From: Martyn White <Martyn.White@arun.gov.uk>
Sent: 27 January 2022 13:53
To: Maria Tomalova <Maria.Tomalova@arun.gov.uk>
Subject: P/163/21/L

P/163/21/L

Pennicotts Farm Pagham Road Pagham PO20 1LN

Listed Building consent for the demolition of existing conservatory to southern side of building & general repair & maintenance of external brickwork & roof coverings, insertion of 2 No

House A Staircase

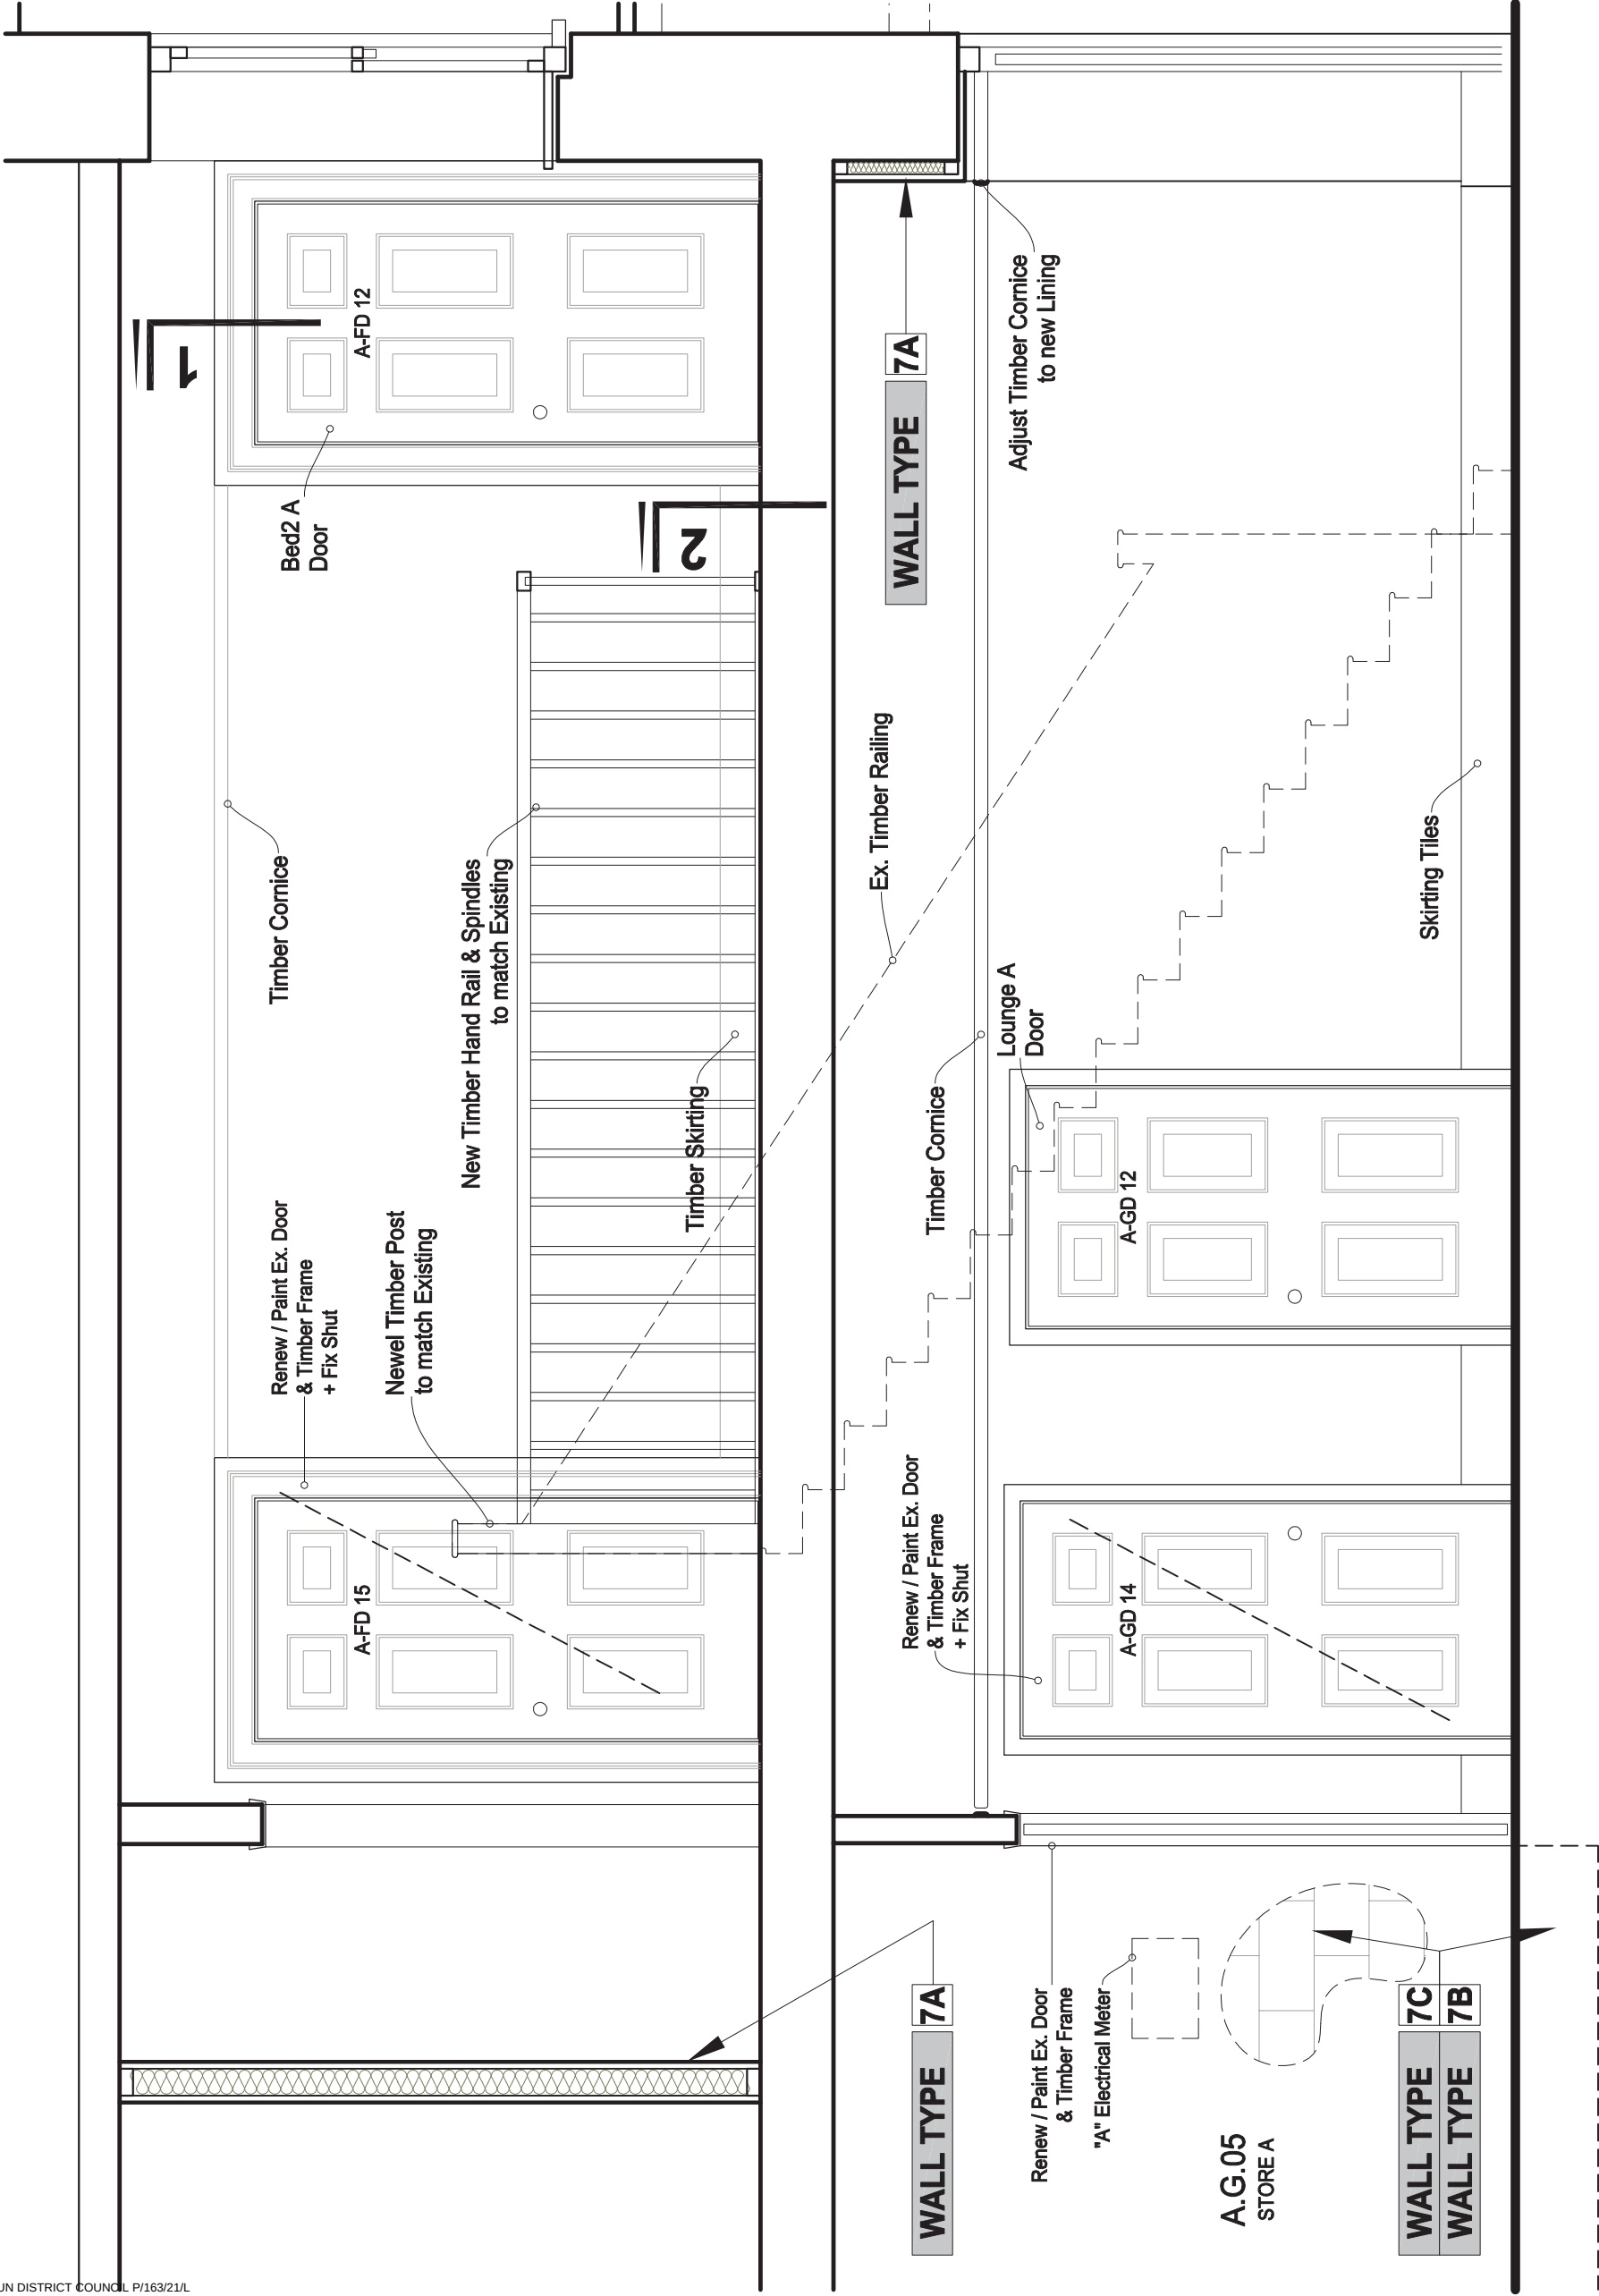
On the floor plan (FF Plan Structure) and 'House B FF Staircase' it looks as though door A-FD15 is removed (reference is made to 'block up opening.....'), whereas in both the plans showing the 'section for house A staircase' (House A section staircase B-B section) and 'House A FF Staircase', the door is to be fixed shut – which is correct? The latter is the acceptable approach, whereas the former is not. There is also another door which will be blocked up and the door recycled, without justification in the first floor of landing B. It is also not clear from the various plans what would happen to the 're-cycled' doors

Project	Title	GF Plan
Pennicotts Farm PO20 1LN	Kitchen	Mr. S.
☐ Draft ☒ Planning ☐ Tender	☐ B. Control ☐ Constr. ☐ Other	Client

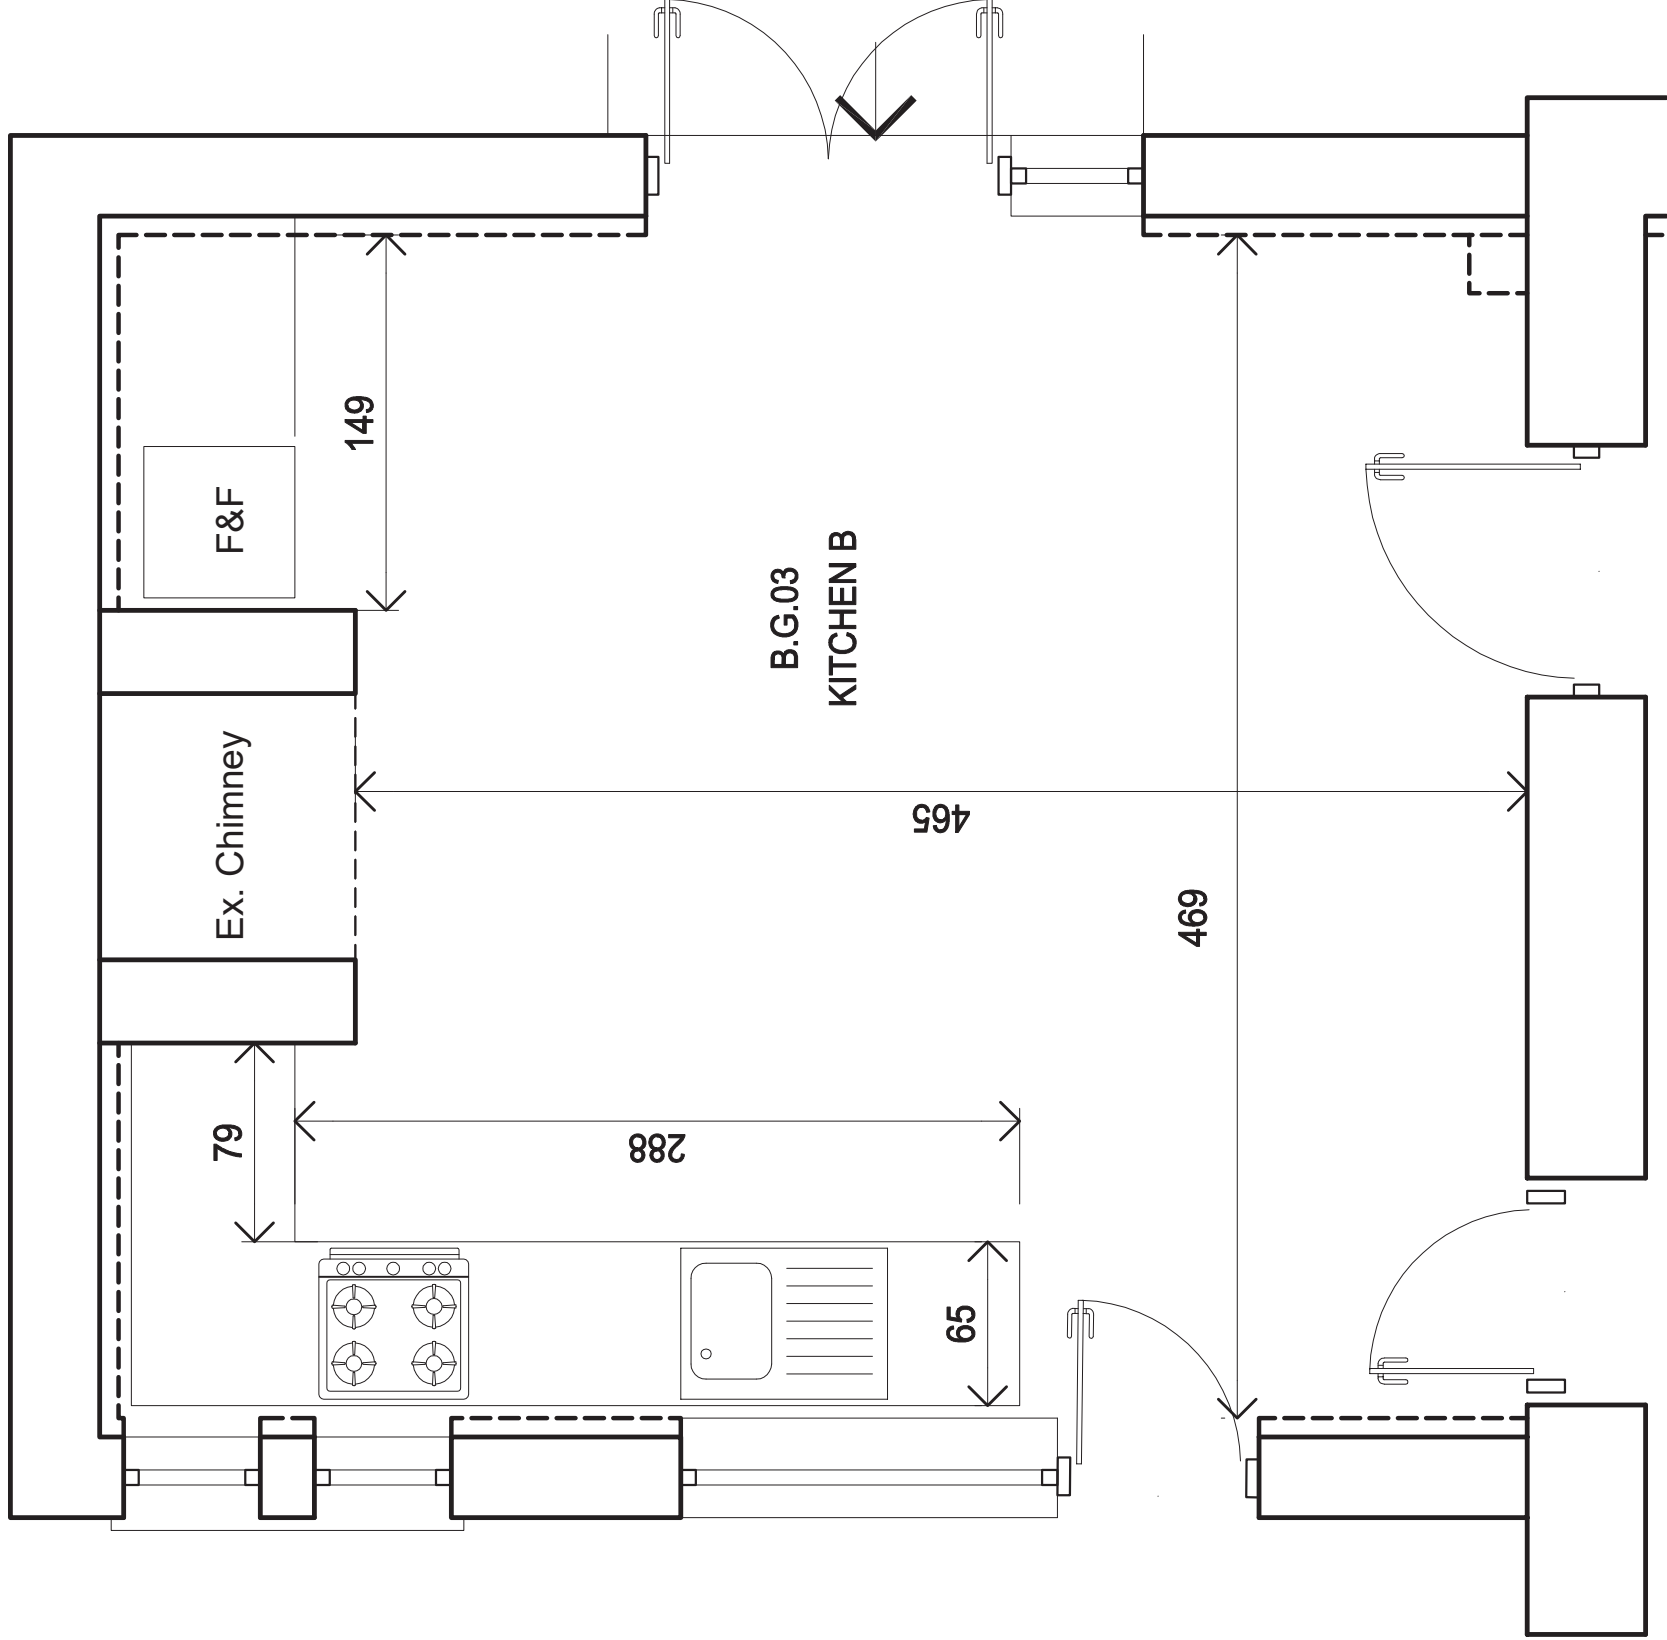
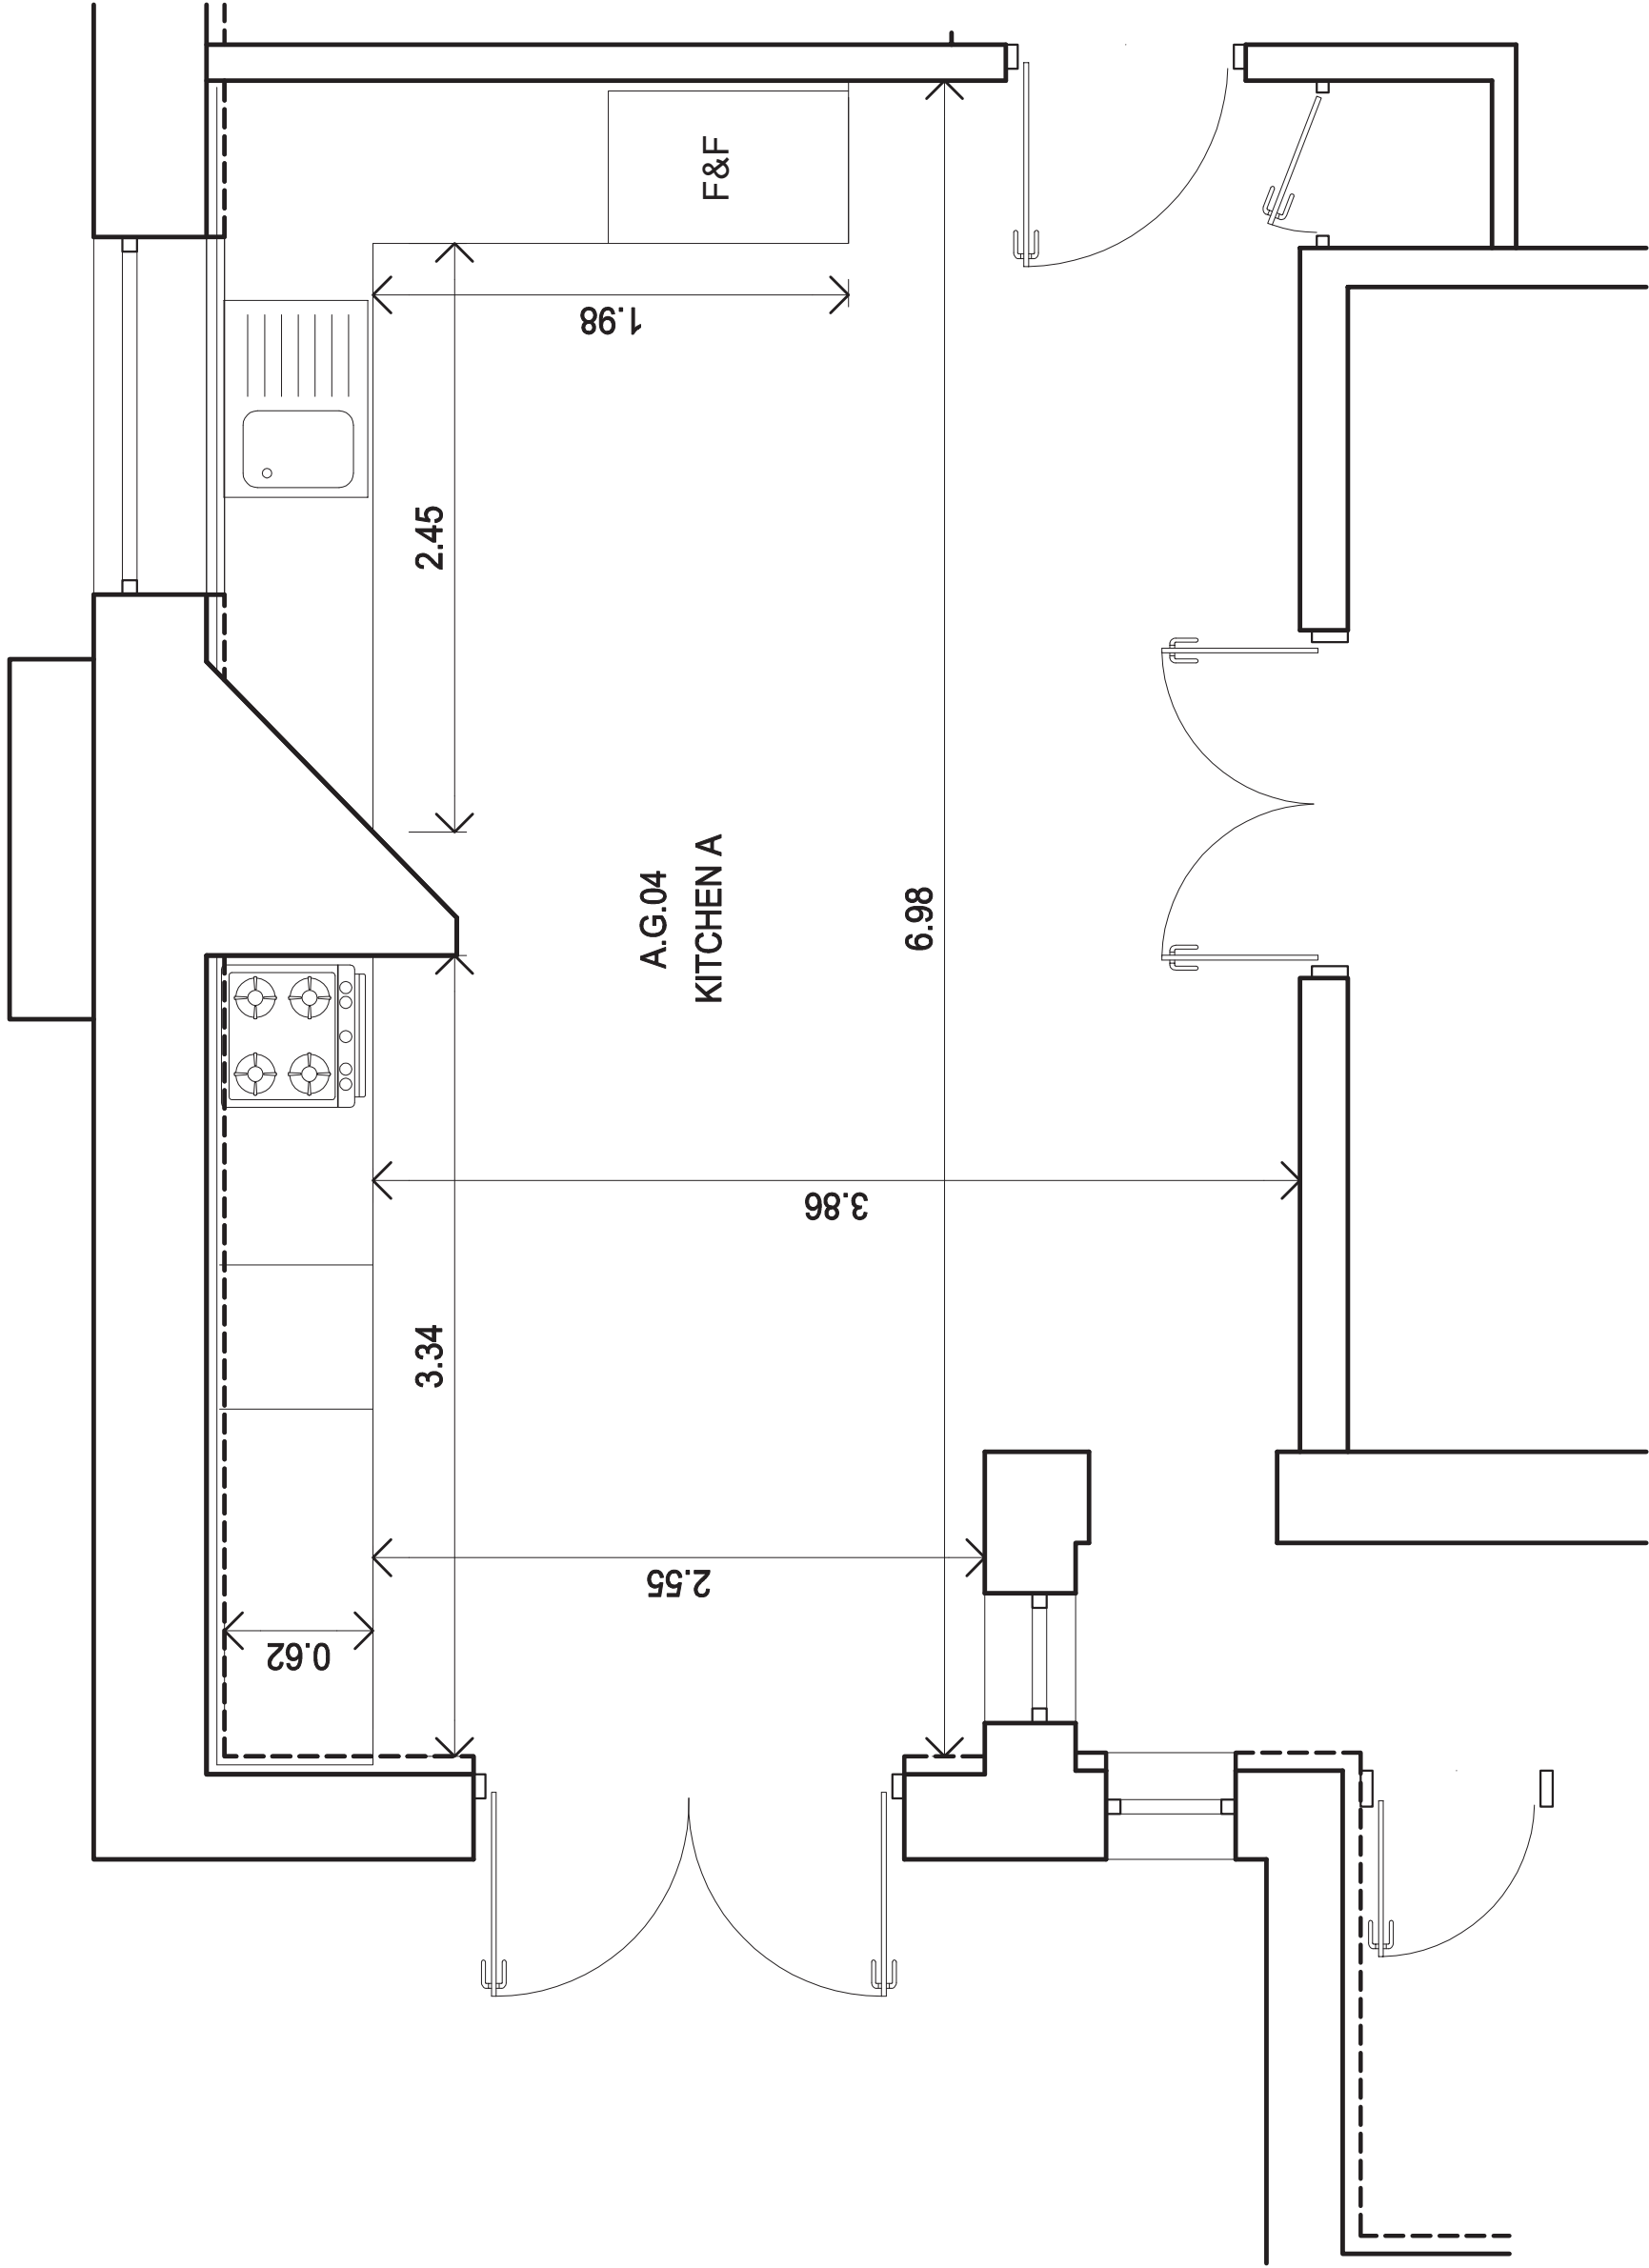
I also note from the ground floor demolition plan reference is made in the area of two windows closest to the rear porch for unit b which states 'remove windows and parapet walls to create new double door'. However, I thought that these windows were to remain, and the window on the other elevation to be replaced by a set of double doors? This approach is confirmed by the proposed elevations and the GF Plan of the kitchen!
